## Villas at Claremont Ranch Comment Responses

### CD's V3

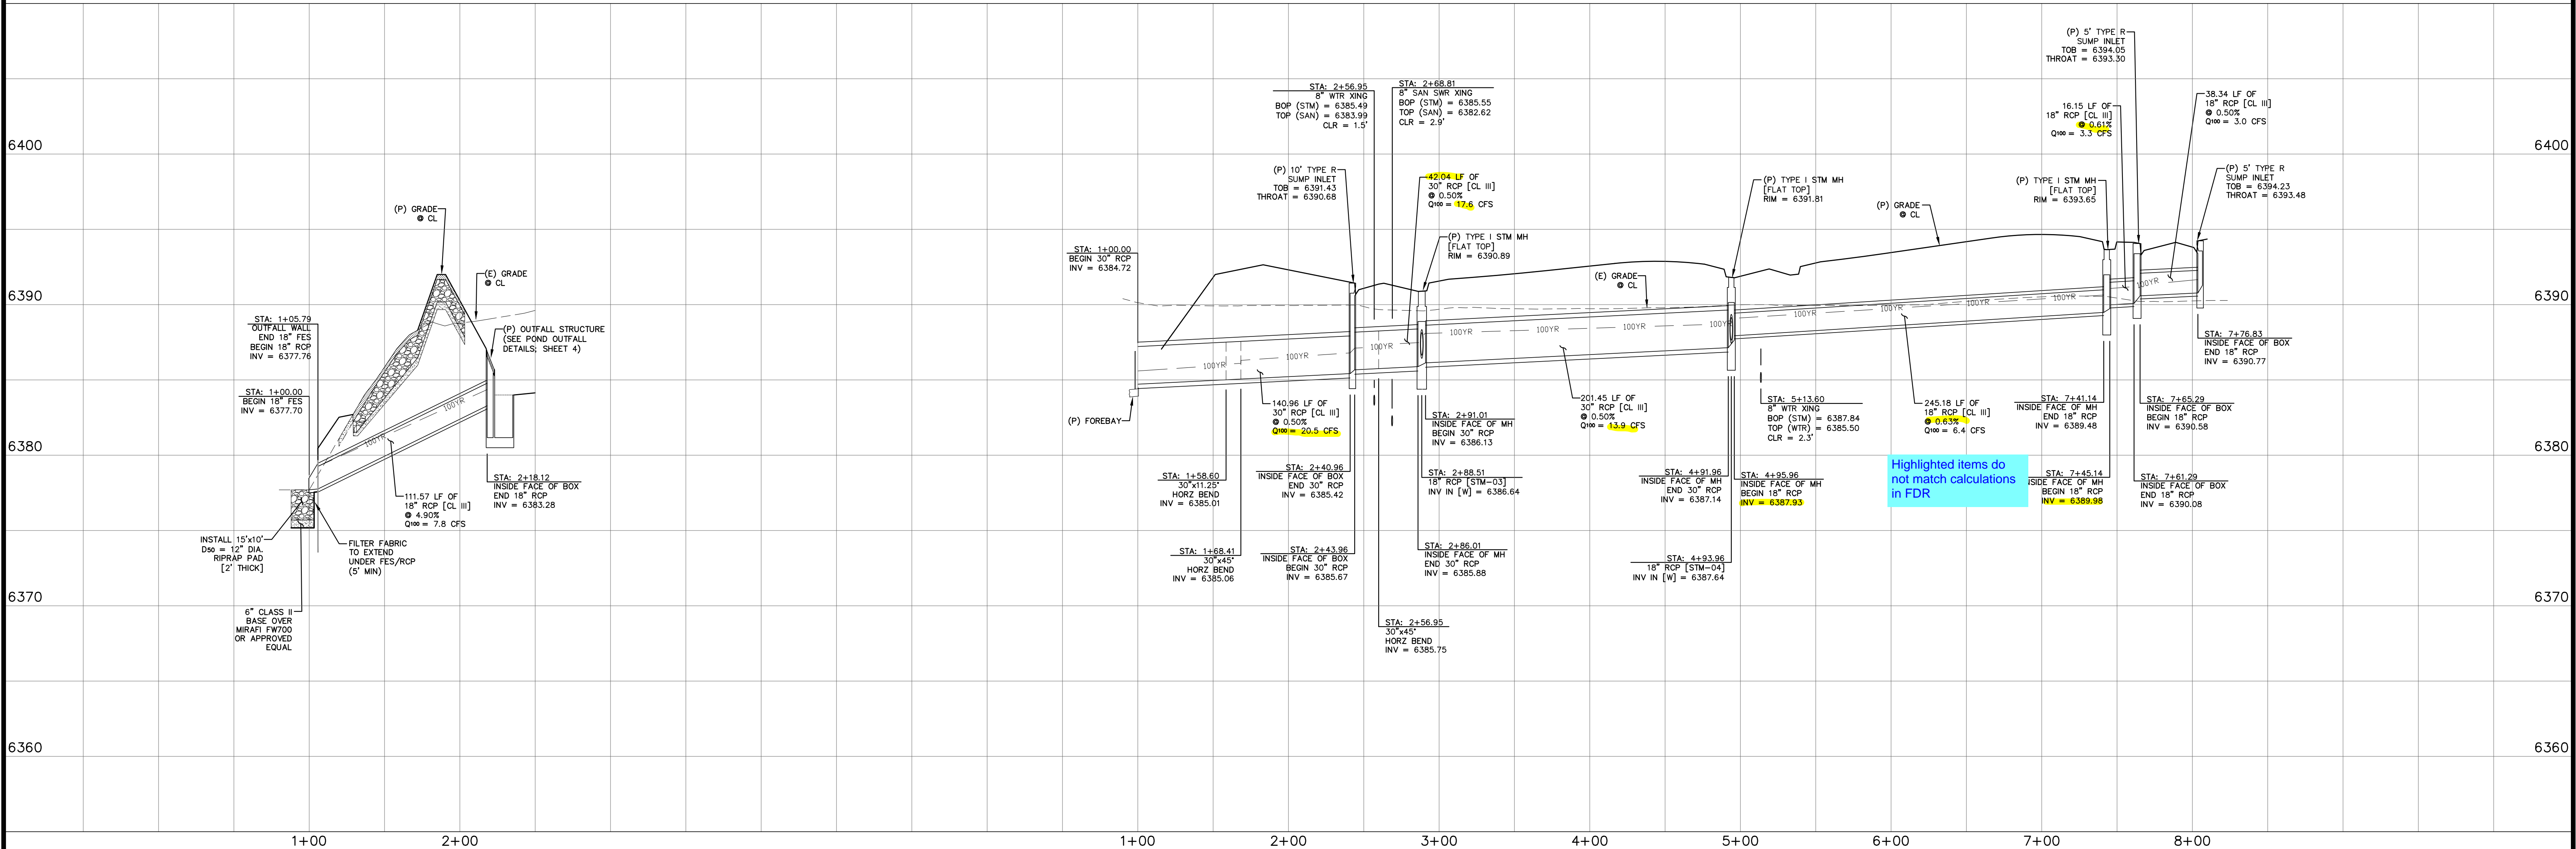
11. Highlighted items do not match calculations in FDR.  
HGL Calculations have been updated. Highlighted items match FDR calculations. Please see note above regarding UD sewer and pipe lengths.
12. Provide detail for riprap outlet protection.  
Rip Rap outlet protection detail has been added.
13. Highlighted items do not match calculations in FDR.  
HGL Calculations have been updated. Highlighted items match FDR calculations. Please see note above regarding UD sewer and pipe lengths.
14. provide detail for handrail.  
Handrail specs and detail are included in this drawing. Additional callouts have been added for clarity.
15. Add curb transition detail  
Curb transition detail has been added.

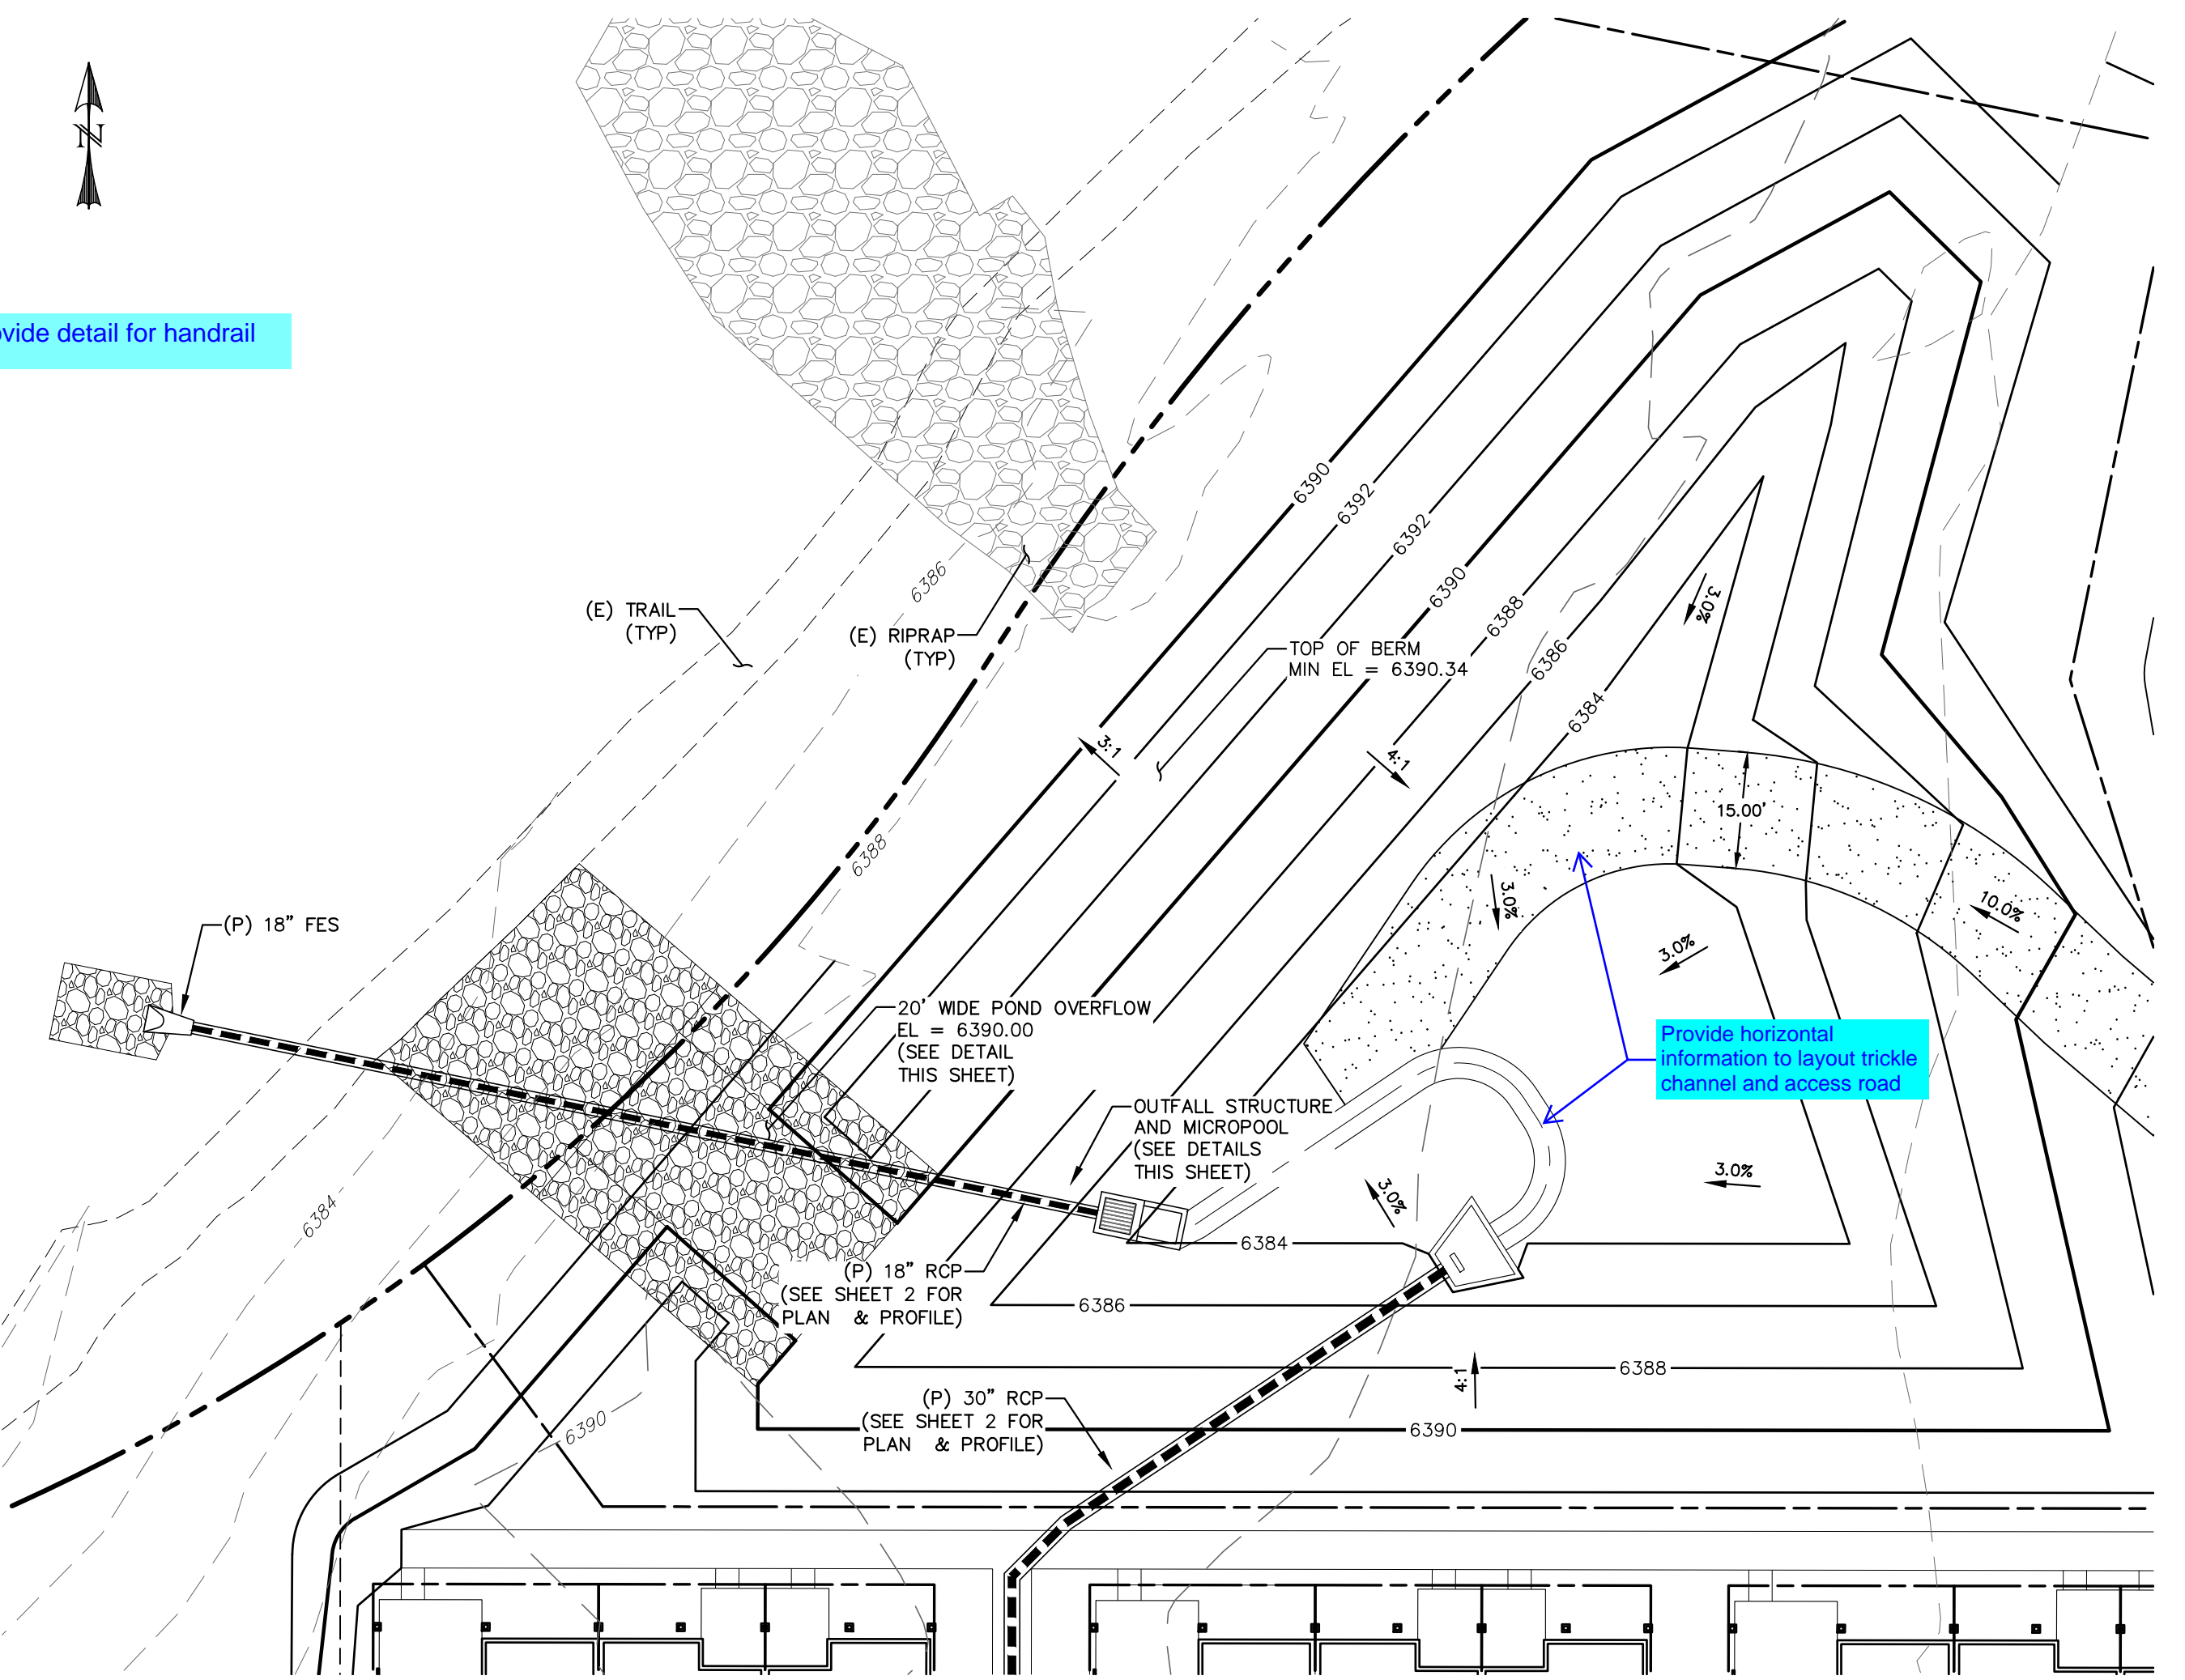
9. Show how pond bottom ties into top of trickle channel curb with min 3% slope towards channel.  
Detail has been modified to show how pond bottom ties into trickle channel.

10. Unresolved comment. This is not an approved alternative, please remove. Diamond plate trash racks are not an equivalent replacement to those in our criteria. We have concerns that the diamond plate is going to be a constant maintenance issue with clogging. Diamonds plates may have the same percent open area as those shown in our criteria but this isn't the only criteria that decides equivalency with the ones spec'd out in our criteria. The well screen and bar grates in our criteria are designed to be maintenance friendly whereas the diamond plate will clog more often.  
Diamond plate has been removed and spec callout has been changed, as requested.
